Demolition of existing garage & outbuildings. Alterations to external materials (including change from thatch to clay tiled roof and brick/stone to fibre cement weatherboarding and coloured render). Alterations to existing fenestration, including to 2 no. ground floor rear bay windows, and addition of first floor front dormer, enlarged balcony at first floor level at the rear. Replacement garages.

The Breakers 29 Tamarisk Way East Preston

Thank you for your internet representation made on 21st January 2020 which has been recorded as '**an objection**' with the comments as follows:

Elevations as Proposed

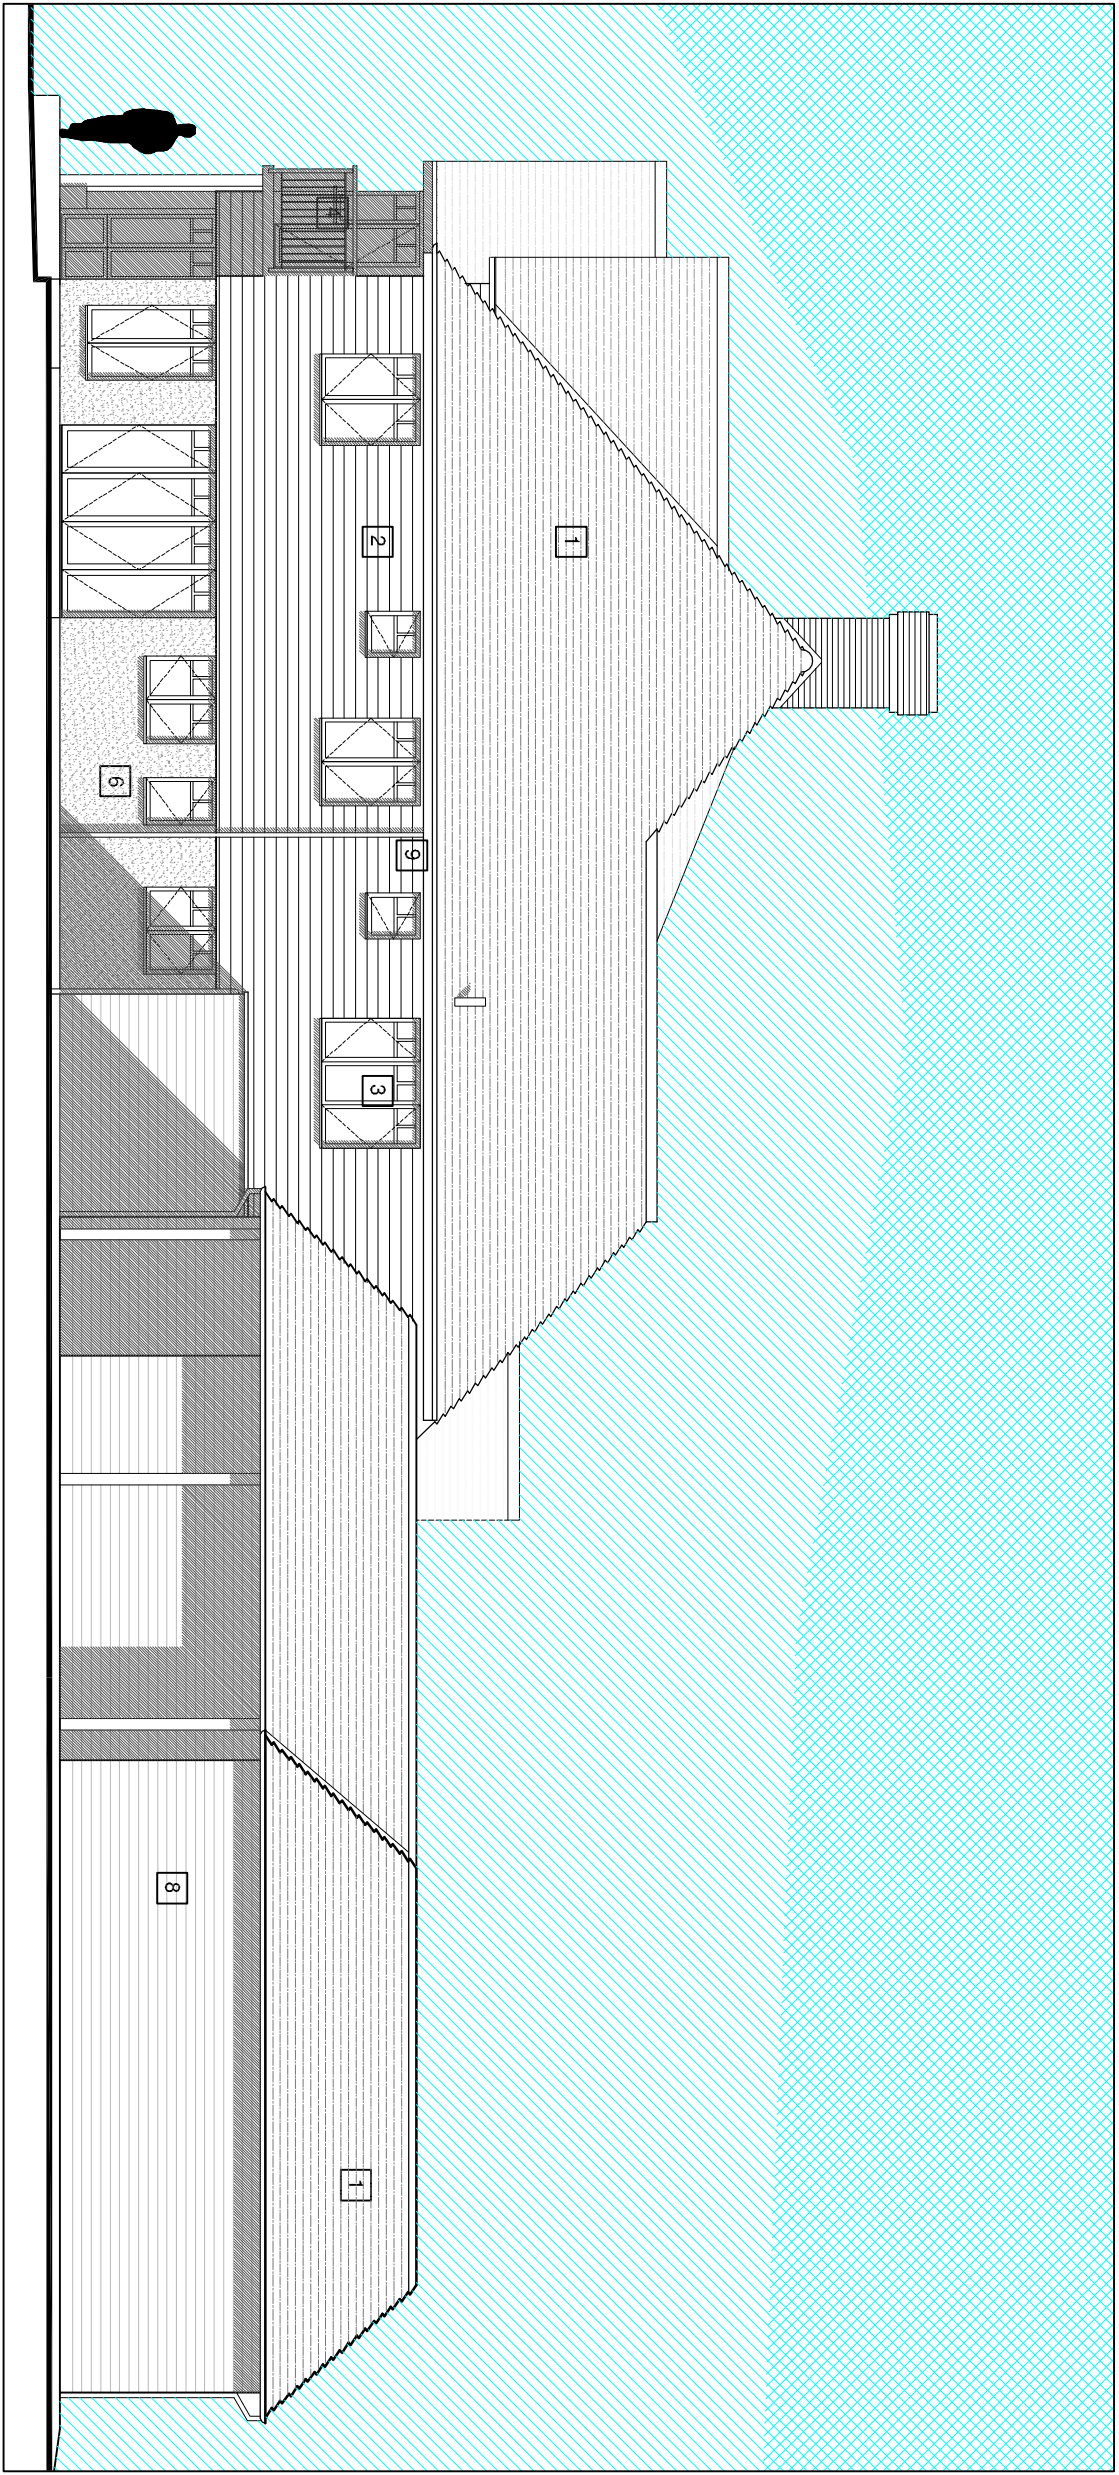
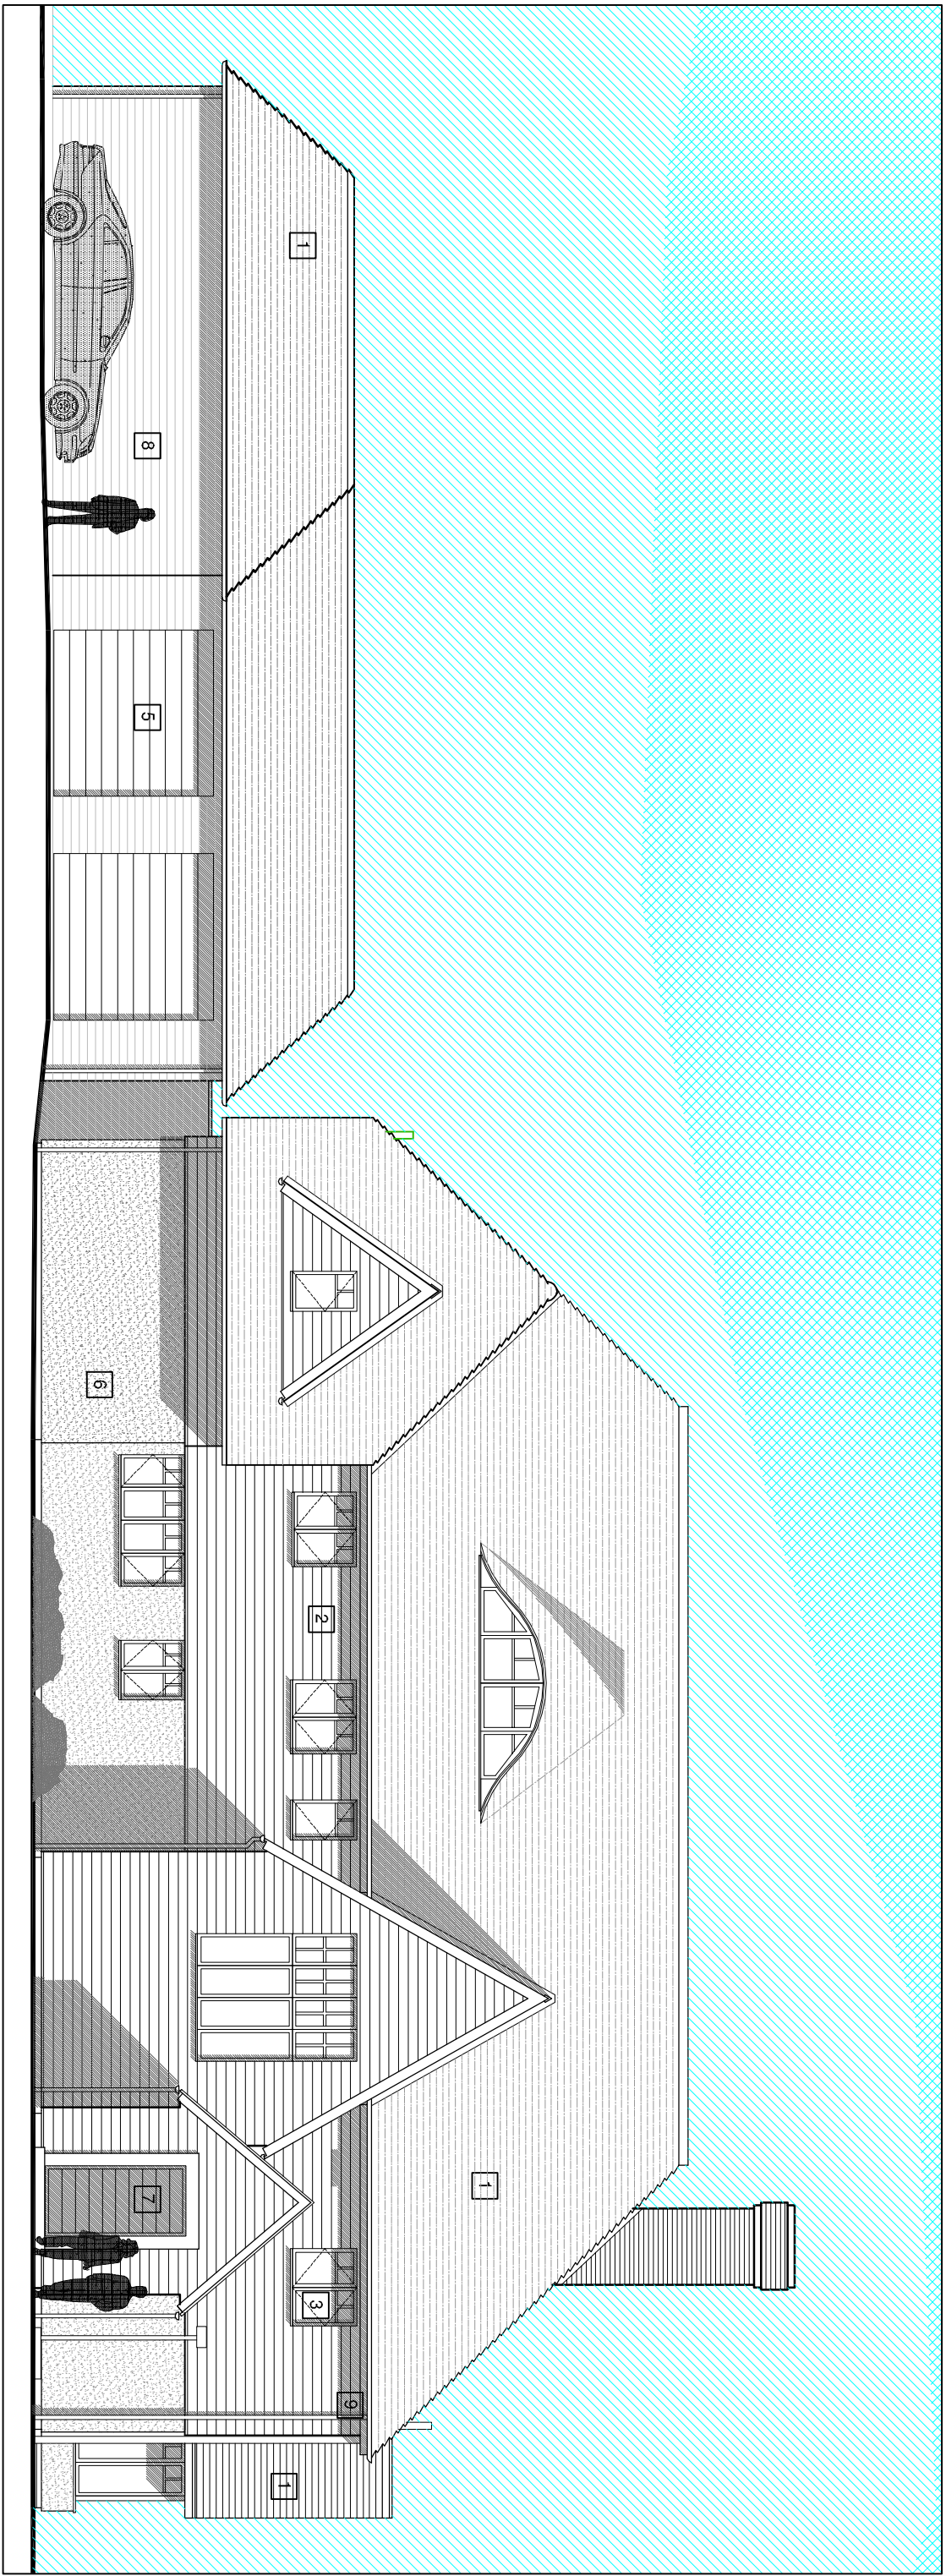
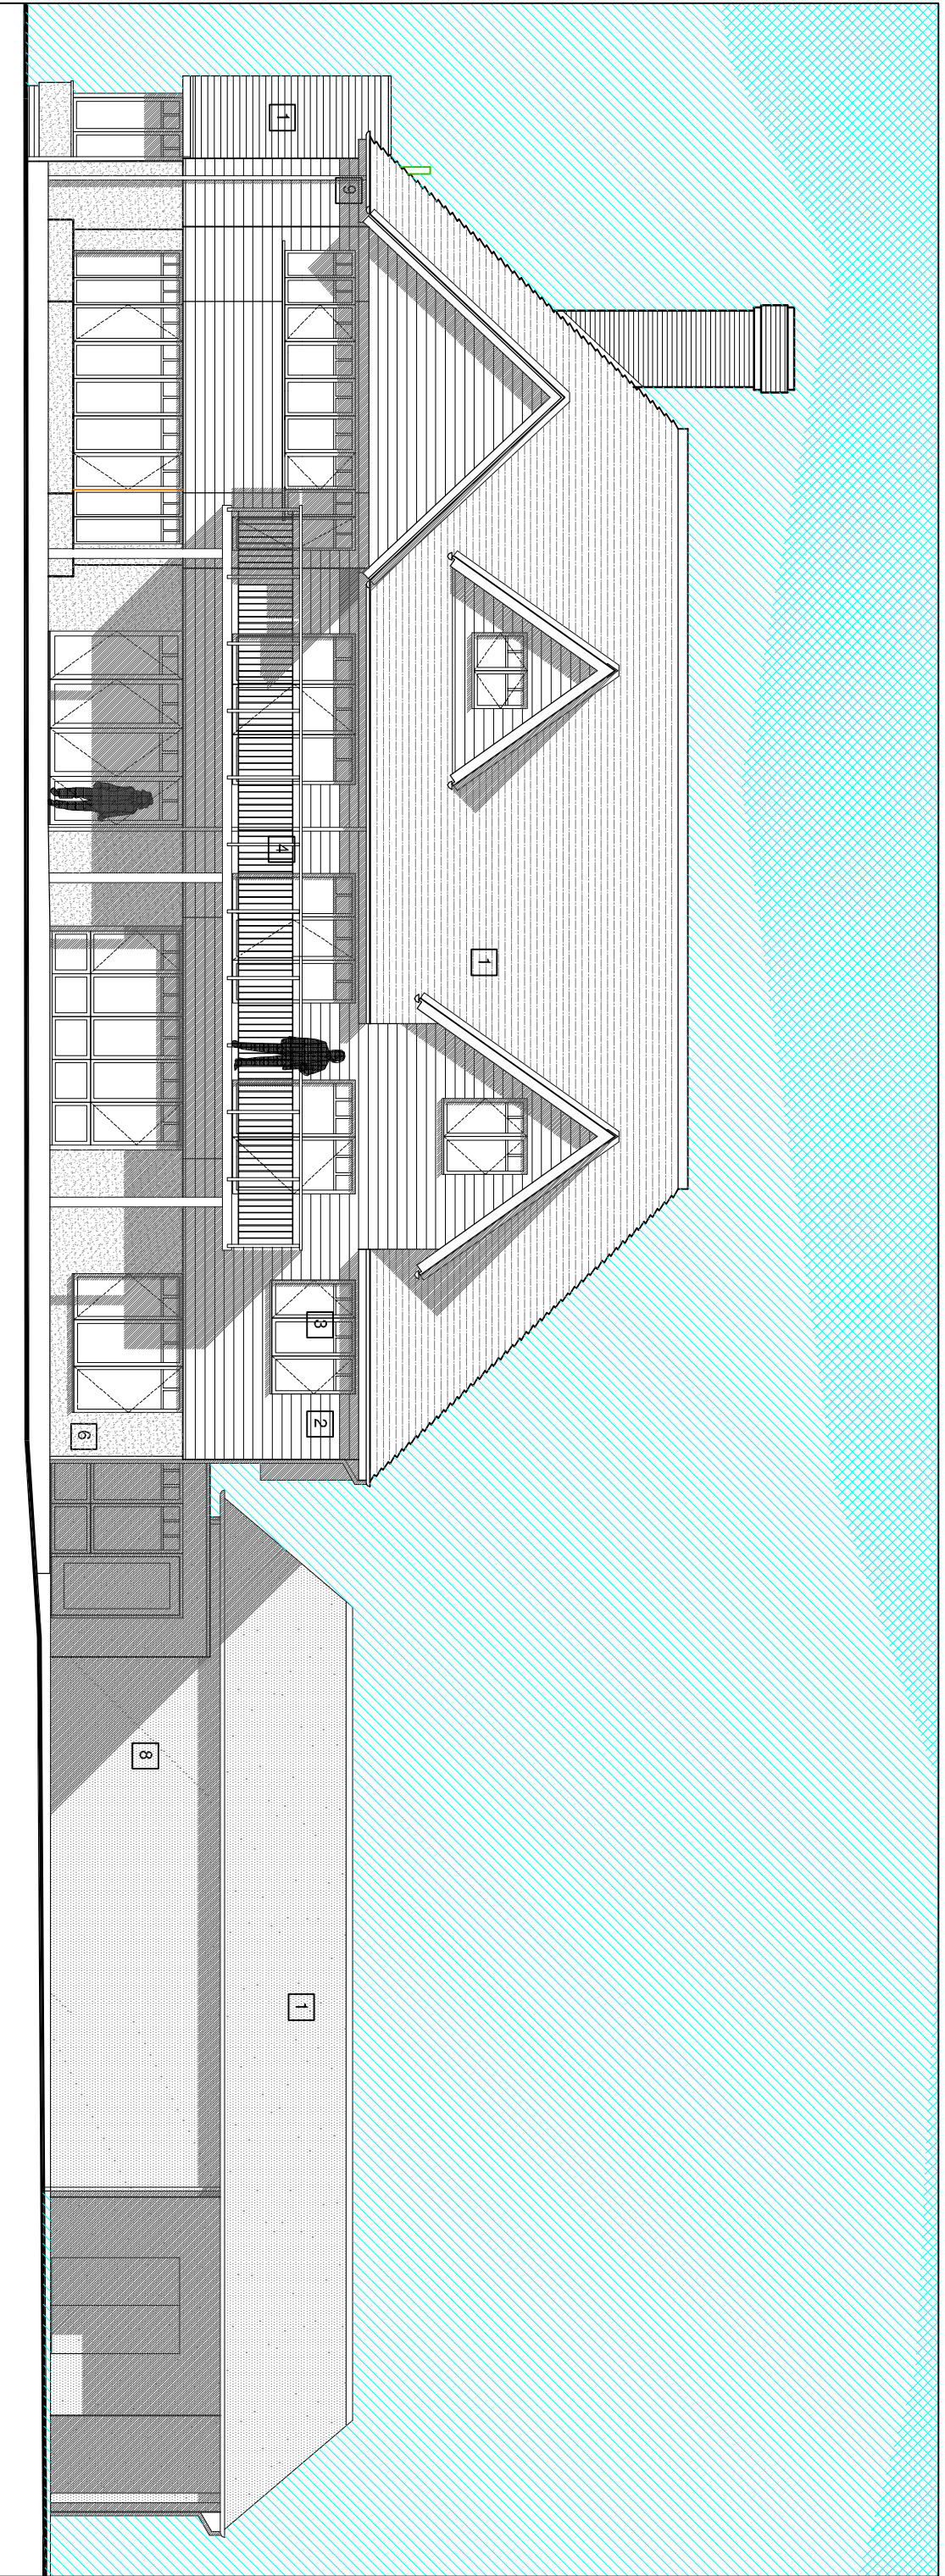
Sad to see the new owner of Breakers wanting to change the house so much, the Thatched roof is magnificent it would be a great shame to change to tiles, The wall looks to be quite tall, altering the appearance of such a lovely home.
